From: Sarah Burrow <Sarah.Burrow@arun.gov.uk>
Sent: 10 August 2021 14:26
To: Planning.Responses <Planning.Responses@arun.gov.uk>
Cc: Simon Davis <Simon.Davis@arun.gov.uk>
Subject: RE: Planning Consultation on: AW/228/21/RES

Engineers Comments Regarding Surface Water Drainage

Application No: AW/228/21/RES

Site Address: Rear of 34,36,38,40 & 44 Carlton Avenue Aldwick Bognor Regis PO21 3LR

Trial Hole: SA1

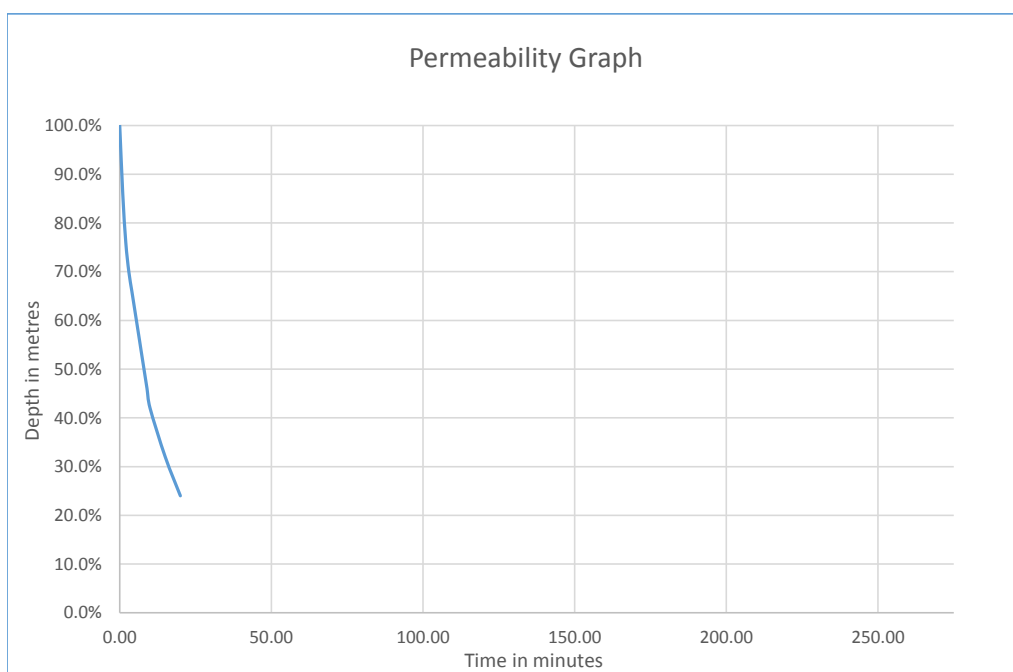
Groundwater monitoring has found groundwater to peak at 49.28m which is 0.52m below ground level [bgl] at WS1. Infiltration testing has shown shallow infiltration to be viable with a worst rate of 8.80×10^{-6} at 0.55mbgl in test pit SA1. This test pit is in the location of the proposed permeable paving.

DRAFT
EXTERNAL LEVELS
SHEET 2 OF 2

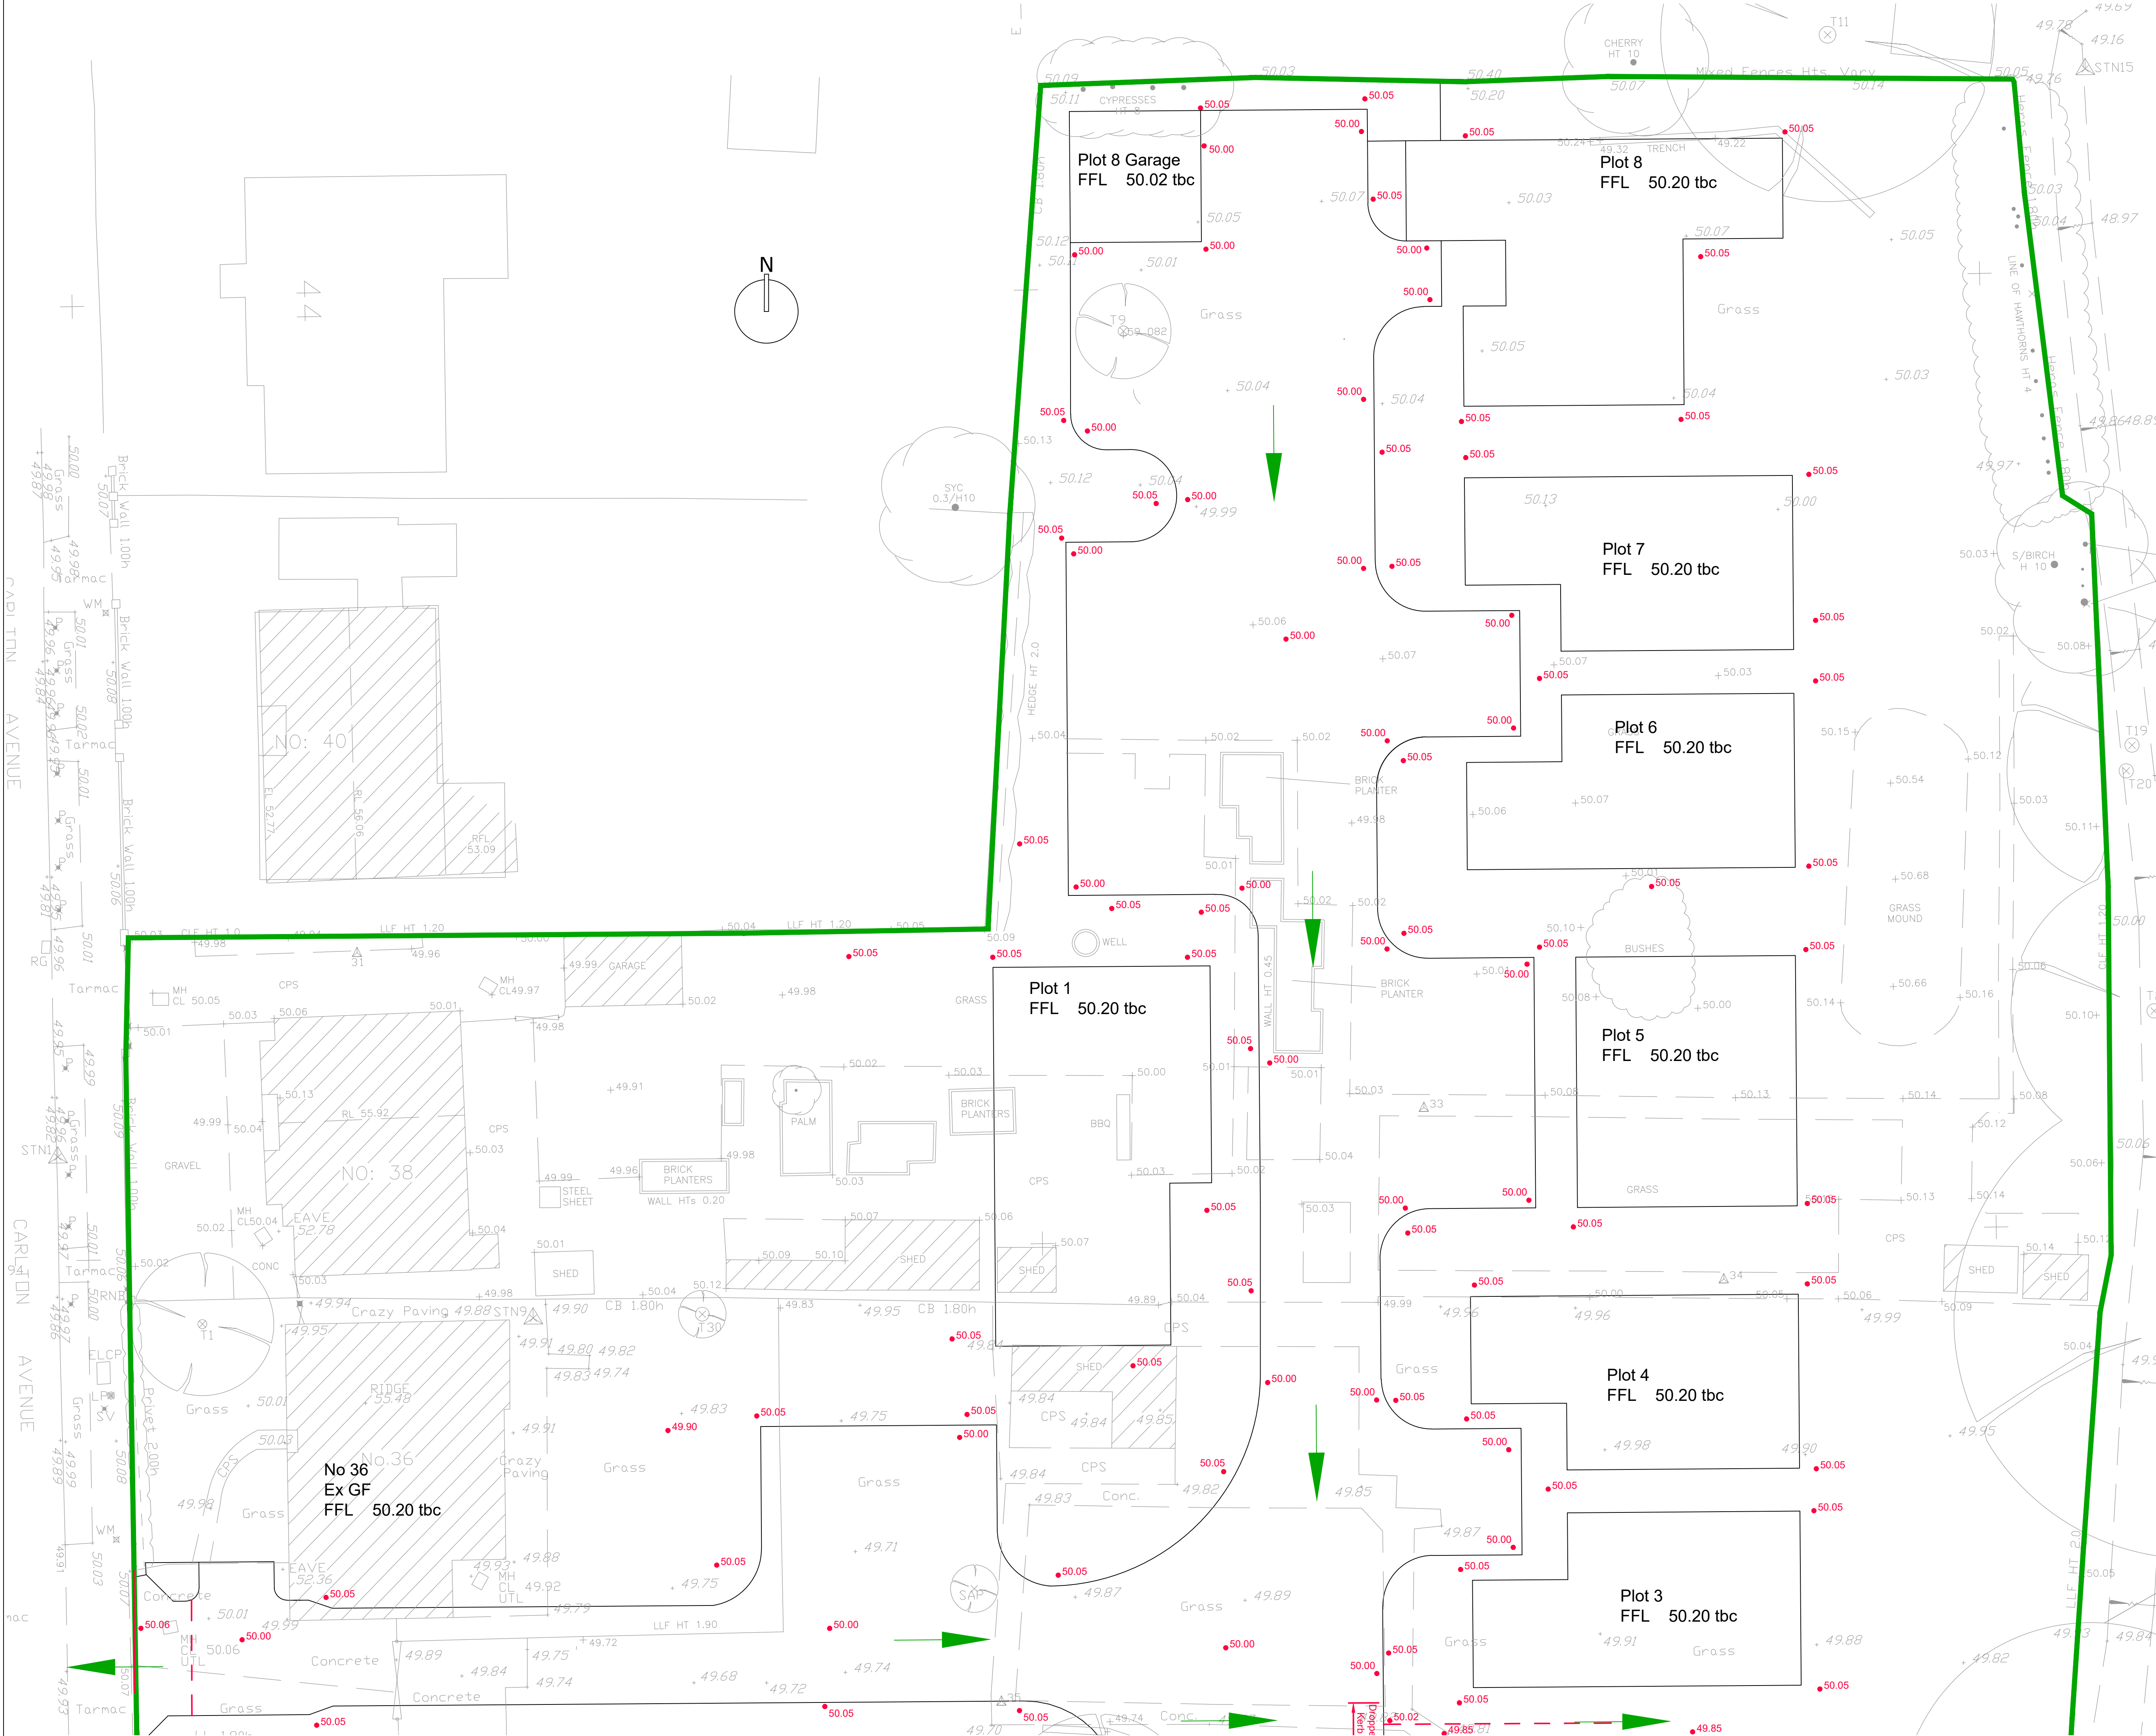
The overarching strategy and proposed levels are acceptable. I am satisfied that sufficient surface water storage is provided onsite.
